Our Ref: M/17/19/PL

**Town & Country Planning Act 1990 (as amended)
Town and Country Planning (Development Management Procedure) (England) Order 2015
Application for Planning Permission**

Development 1 No. 1-bedroom dwelling (resubmission following M/99/18/PL).
Location 14 Baldwin Close Middleton-On-Sea

AR-129-03/A

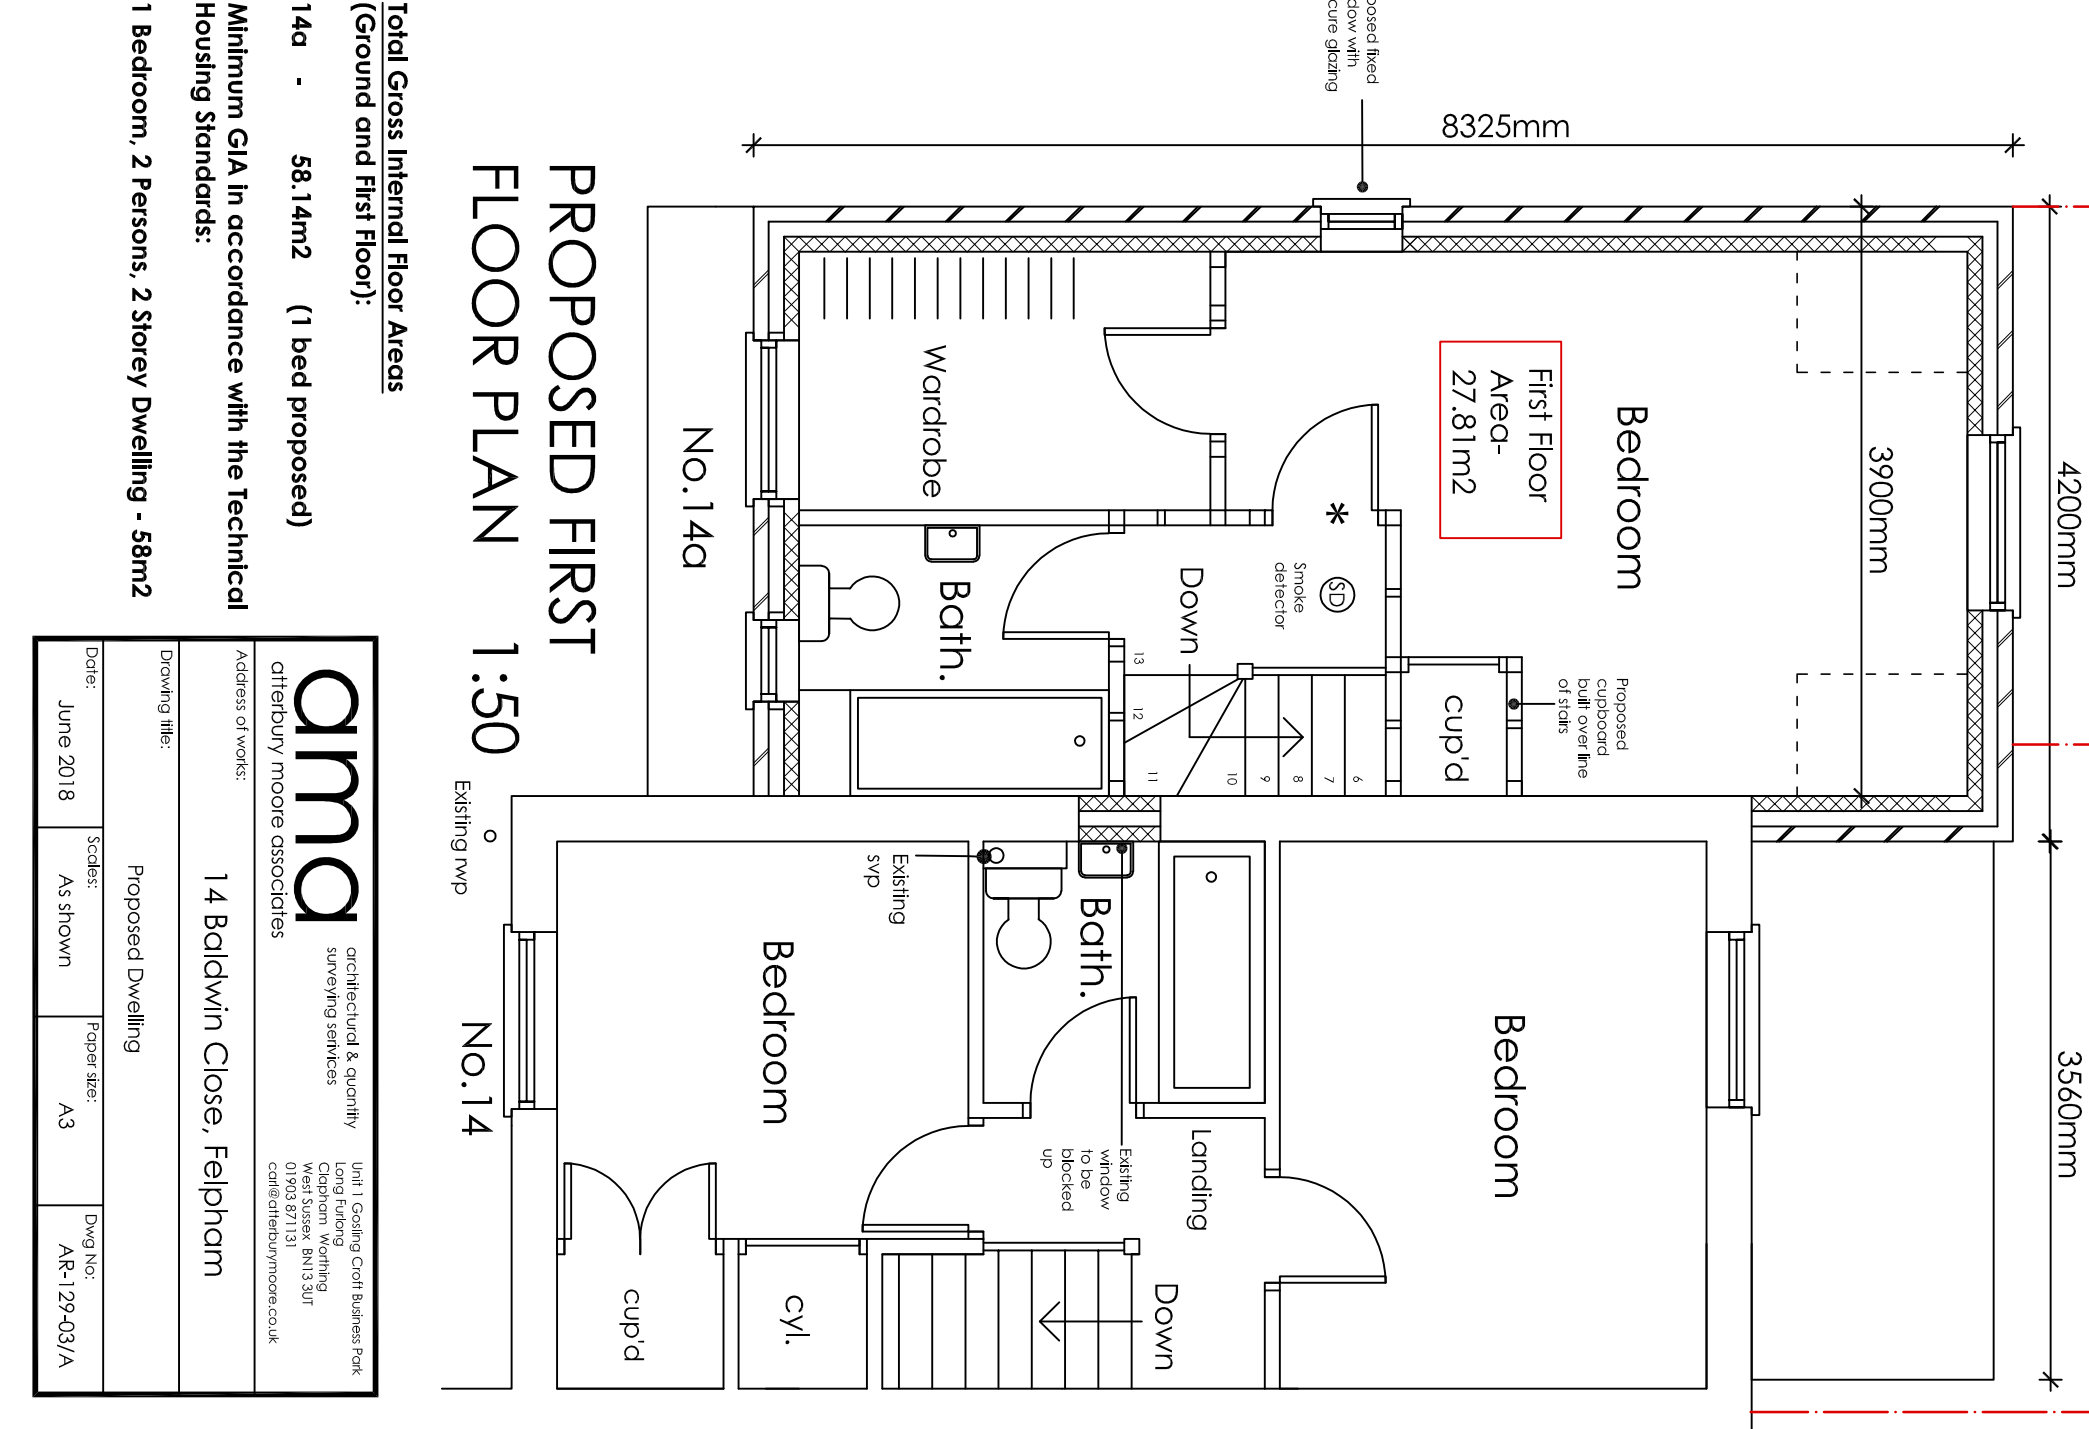
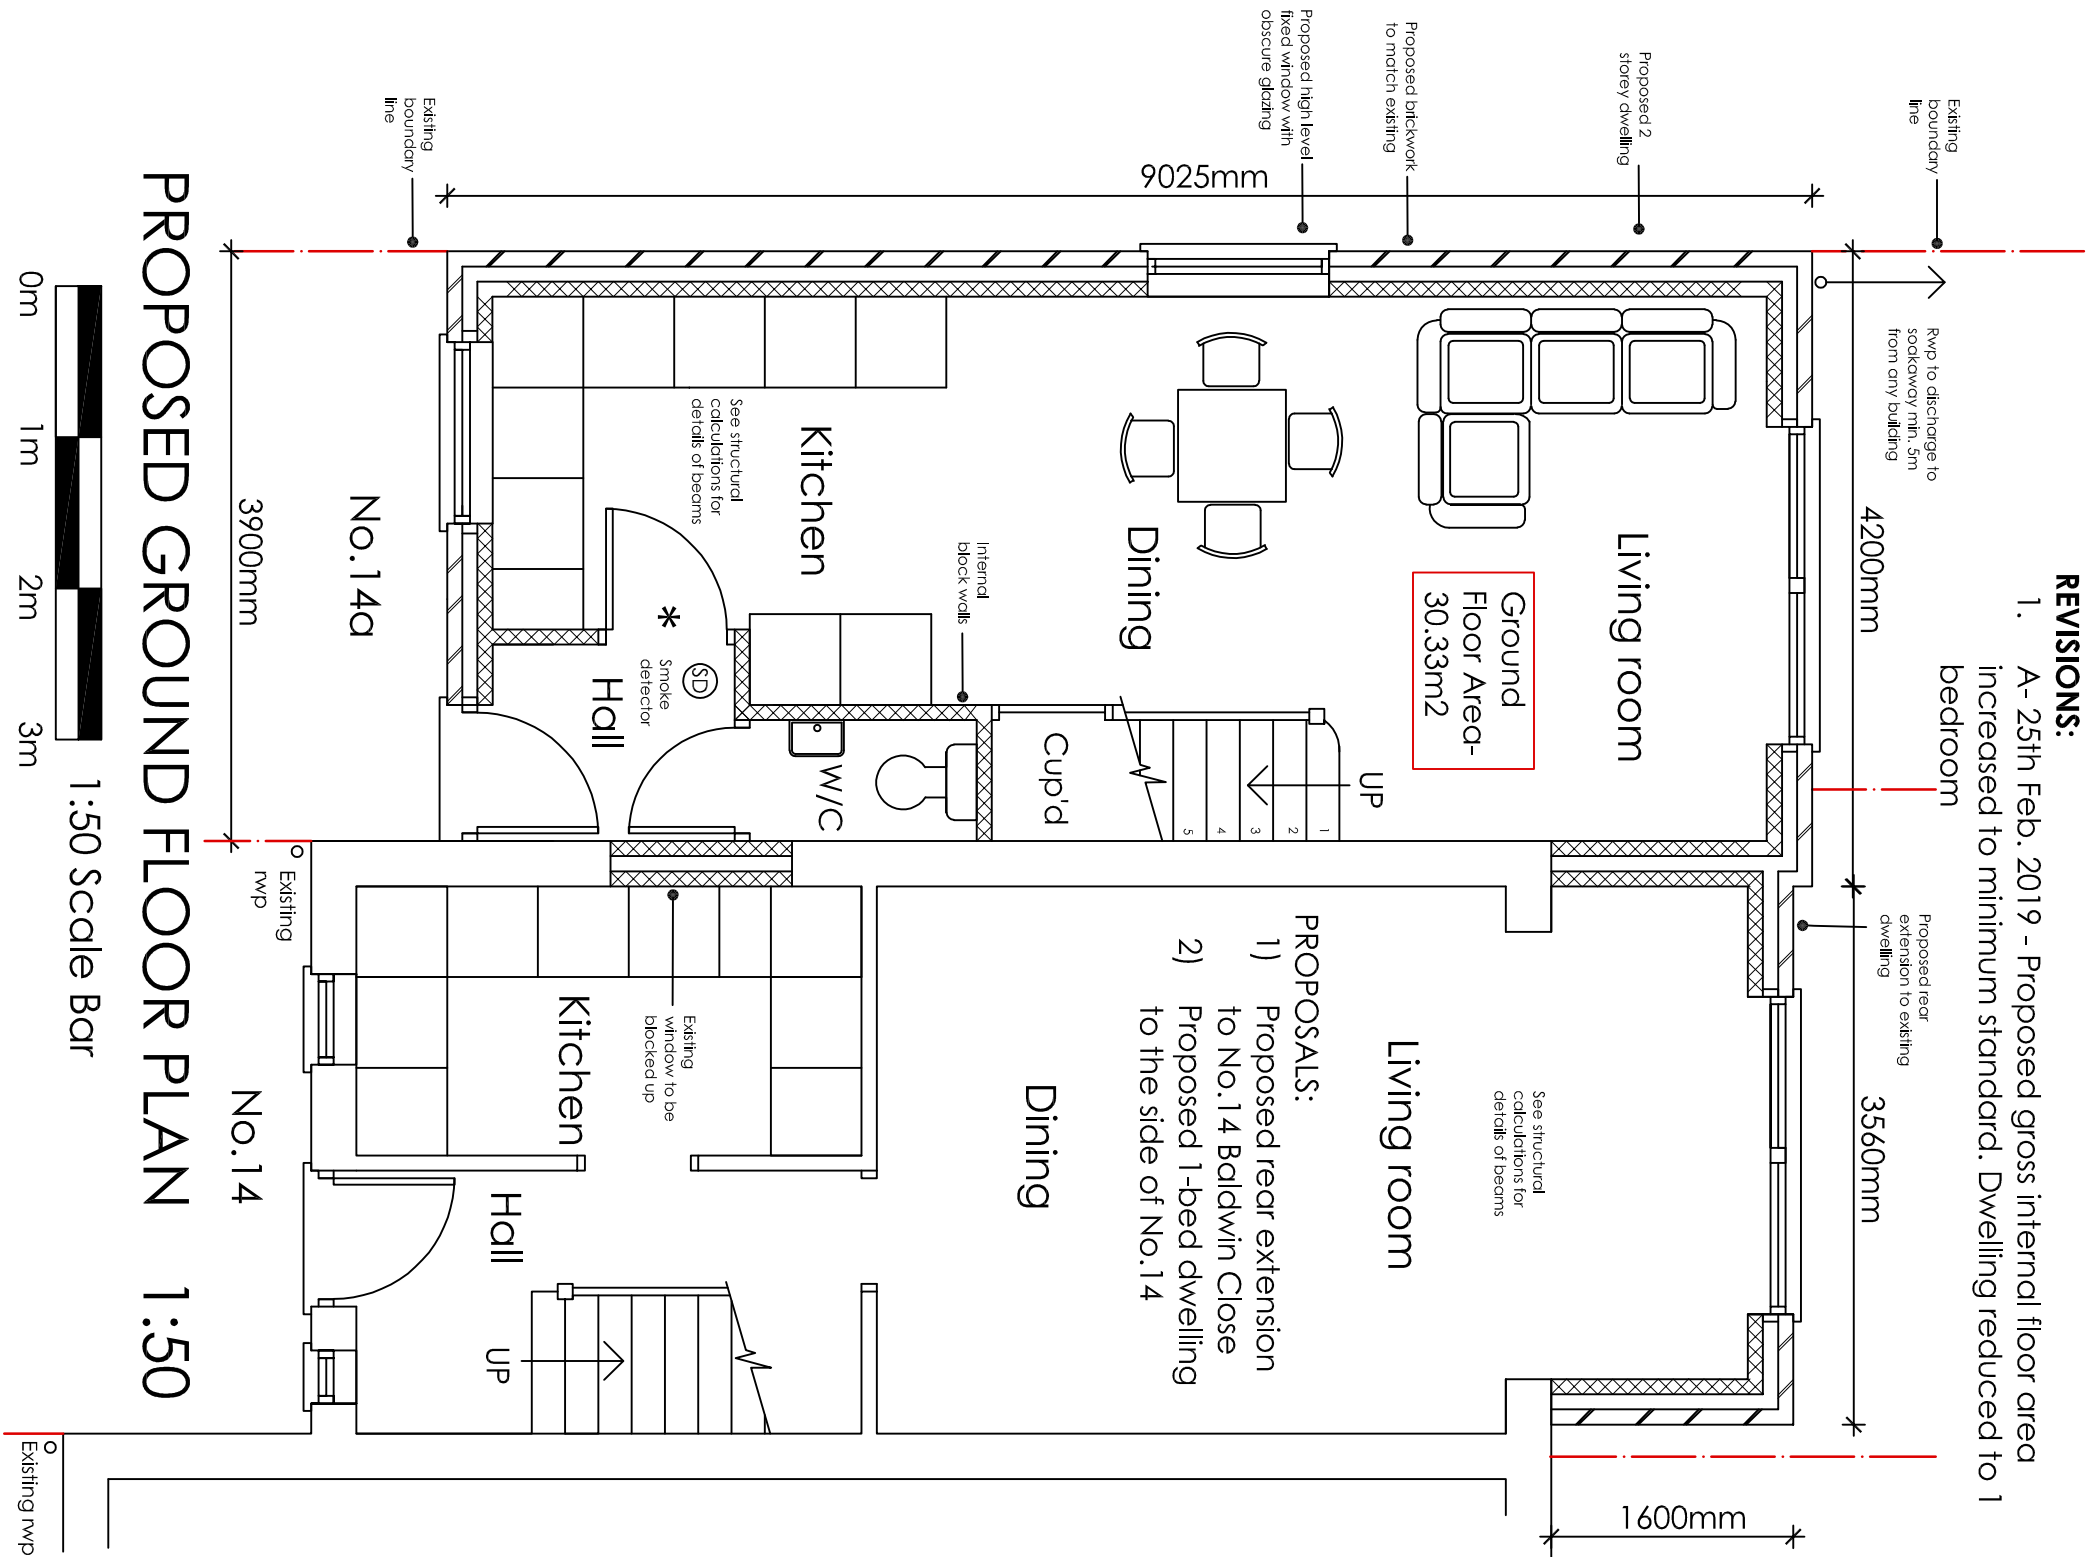
On the garden plan, the new dwelling has been annotated as a '2 bed dwelling'. Please change to '1 bed dwelling' or take number off to read 'dwelling' to avoid confusion.
